A1 in Northumberland - Morpeth to Ellingham

11th January 2021

Application by Highways England for an Order Granting Development Consent for the A1 in Northumberland – Morpeth to Ellingham project

Examining Authority's (ExA) First Written Questions

**Appendix B Working Area around West Linkhall Scheduled  
Monument and North Charlton Scheduled Monument**

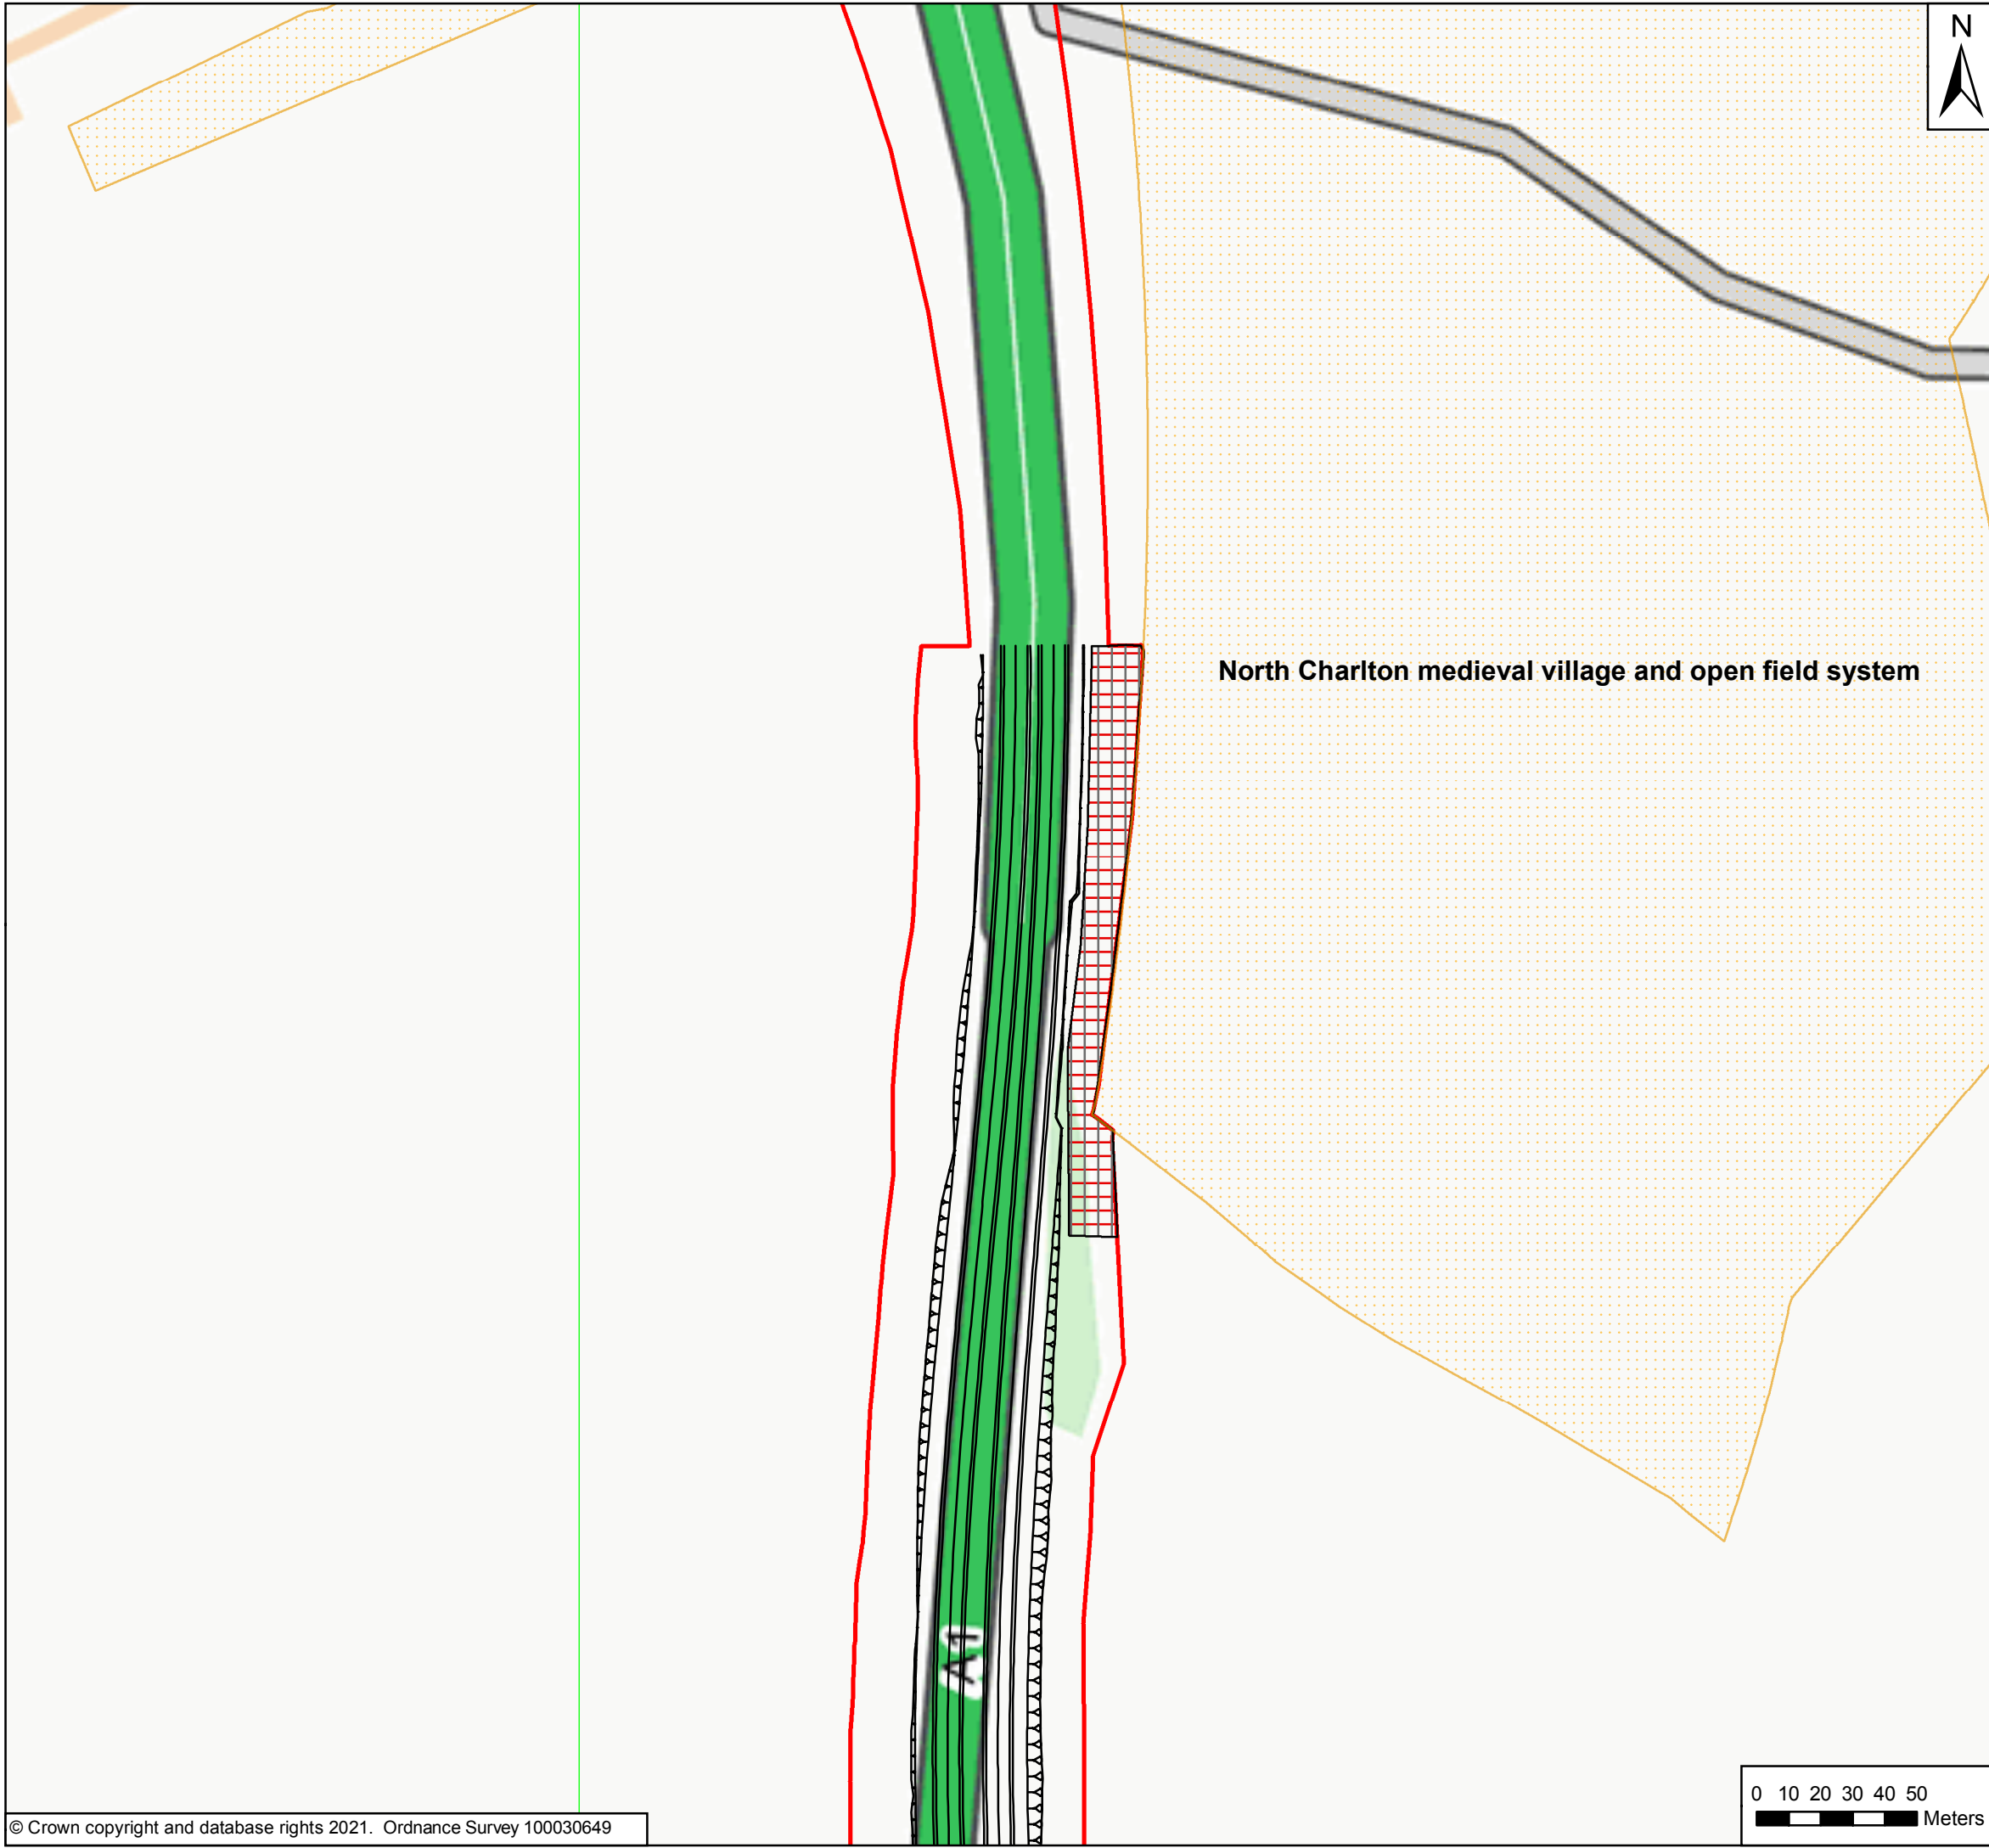
Historic England response - at this stage it is unclear as to whether direct physical impacts on scheduled monuments will be avoided.

However, the plans submitted do not show the boundary of the DCO and the boundary of the scheduled monuments on the same plan, and at a sufficiently high scale to be able to confirm that this is indeed the case.

This means that whilst we don't doubt the intention of avoiding the scheduled sites, at this point we cannot be definitive that physical impacts on scheduled monuments will be avoided. To resolve this, our suggestion is for the applicant to submit such a plan, showing the DCO boundary and scheduled monuments on the same high scale plan.
